May 21, 1986

RE: 308 Mountain Road (J-14/D32)

GRADING & DRAINAGE PLAN

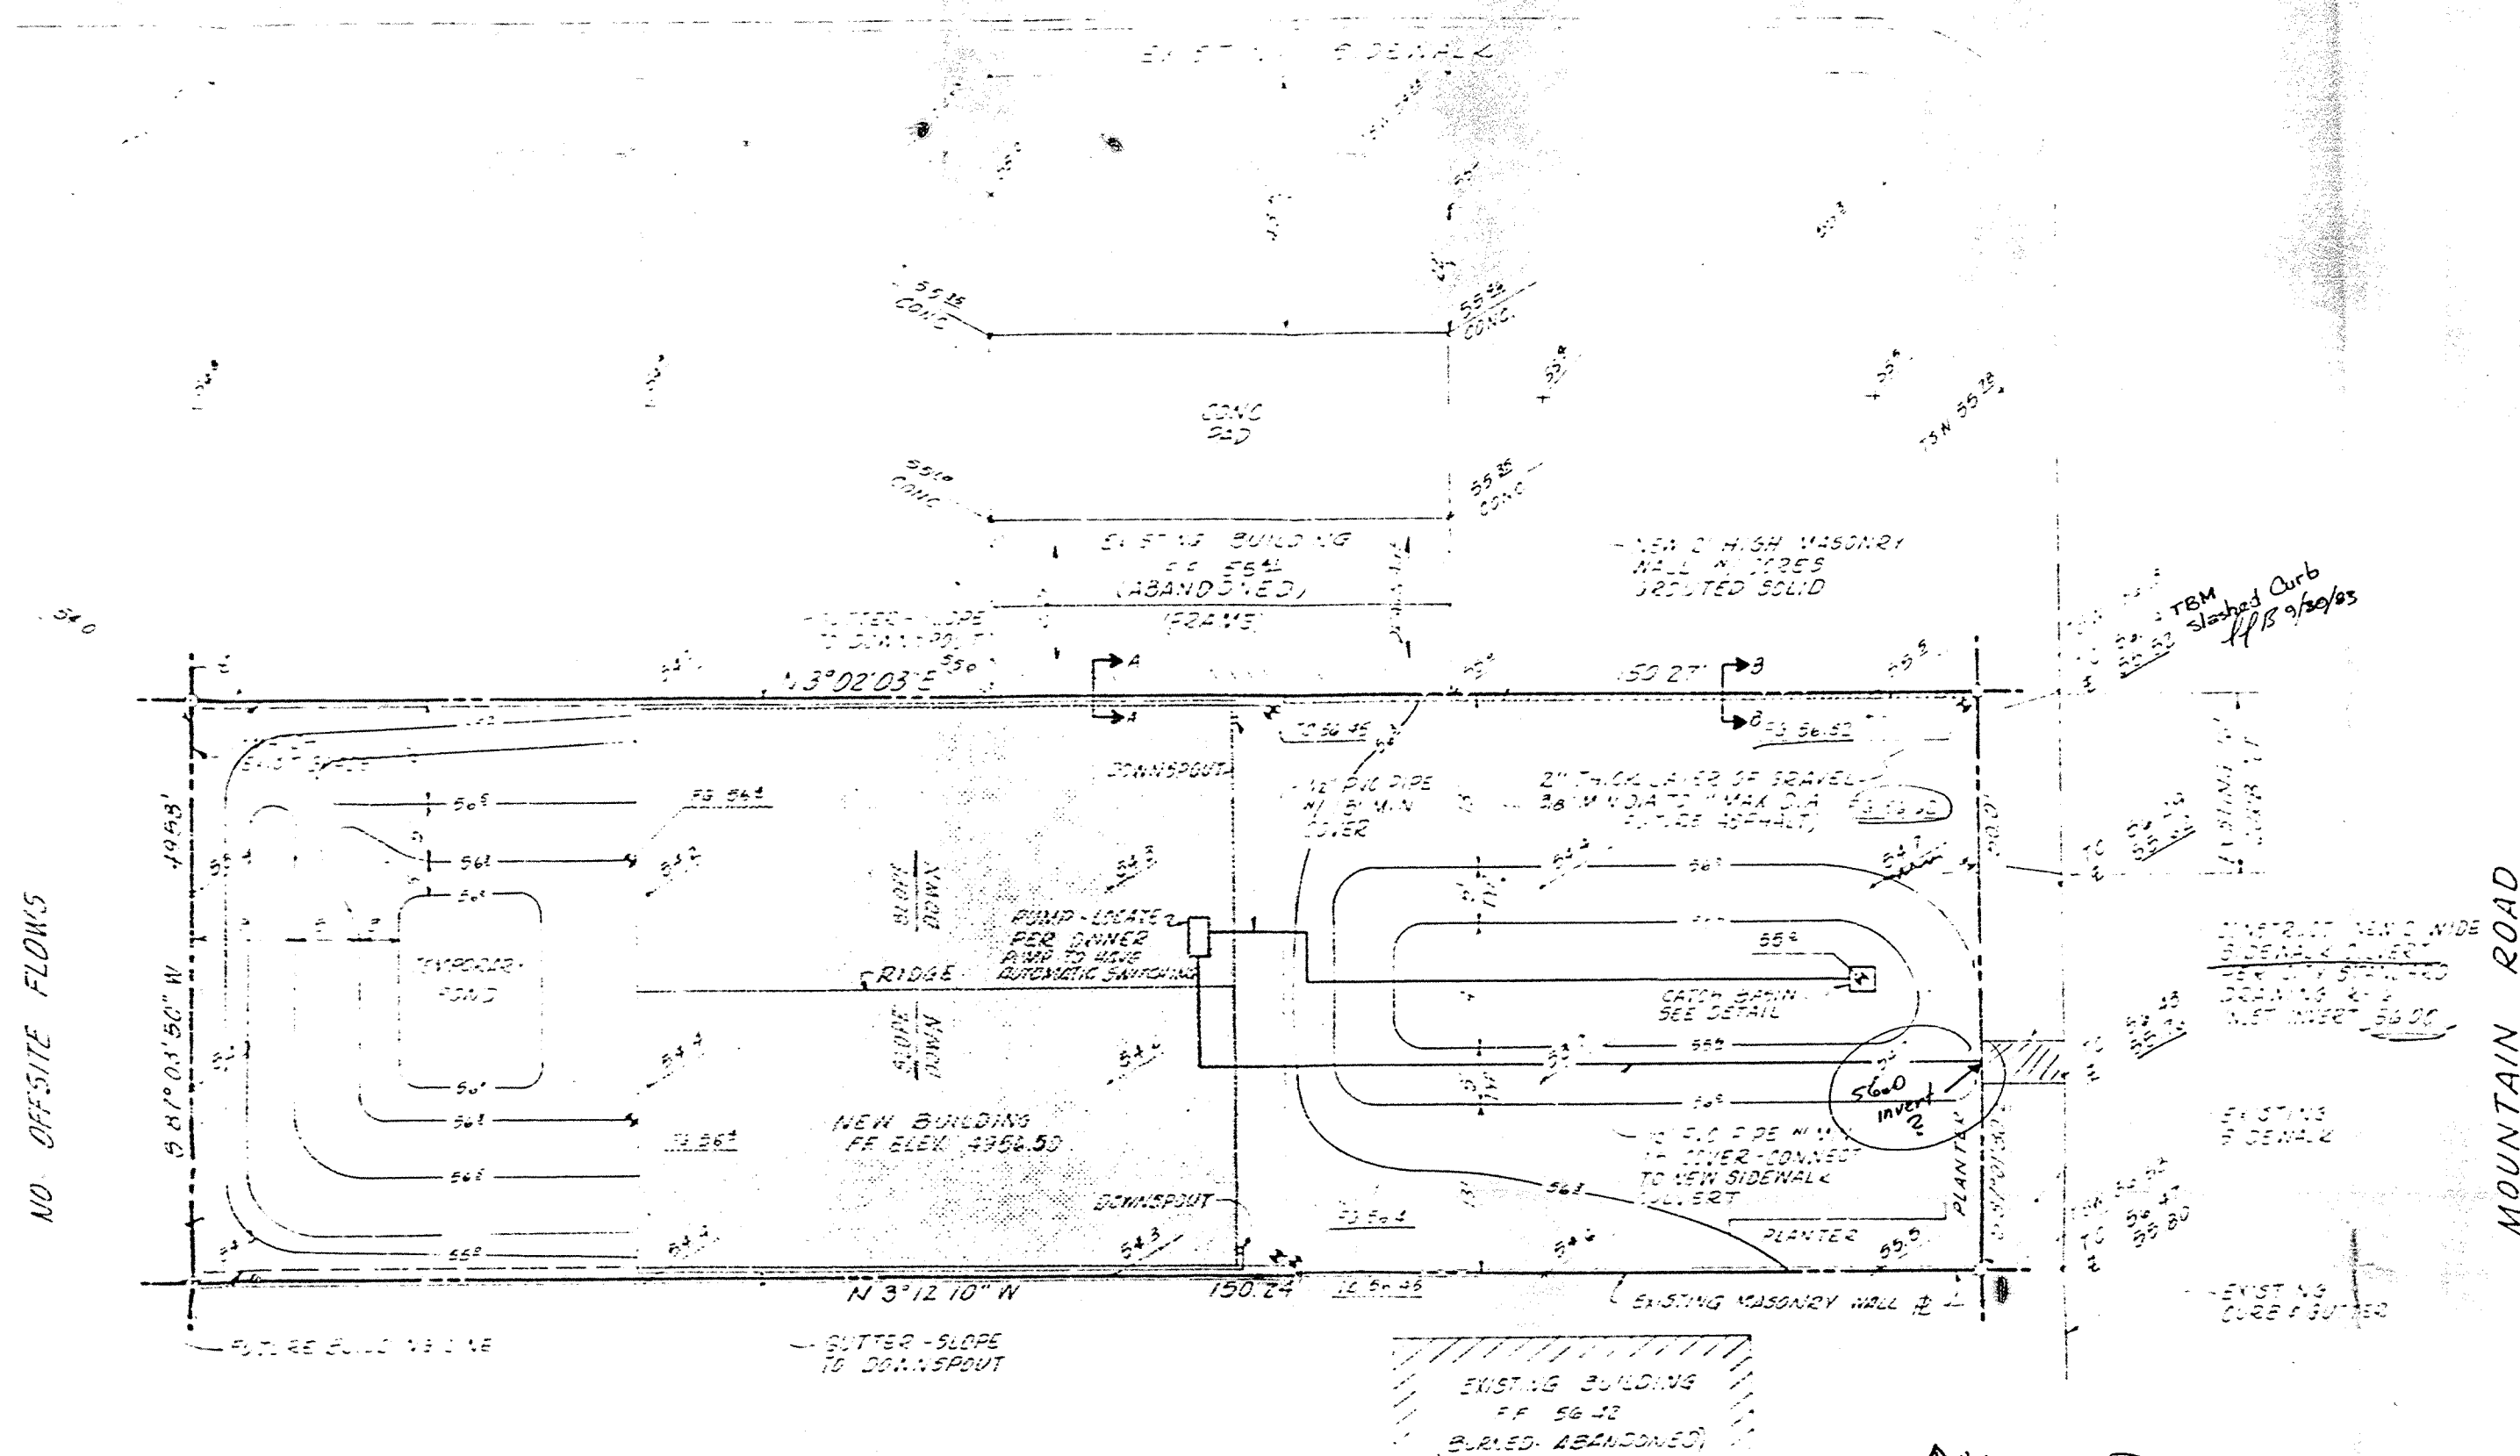
As per our telephone conversation (this date) I am requesting that the approved drainage plan be revised by this letter to eliminate the fixed position sump pump. It is further requested that the owner be allowed to use a portable pump in lieu of the original design.

This request will affect the land of the property owner only as the pump is in a pond in his parking lot. Overflow from the pond (assuming the pump is not used) is directed to Mountain Road through an in-place sidewalk culvert and the drive pad.
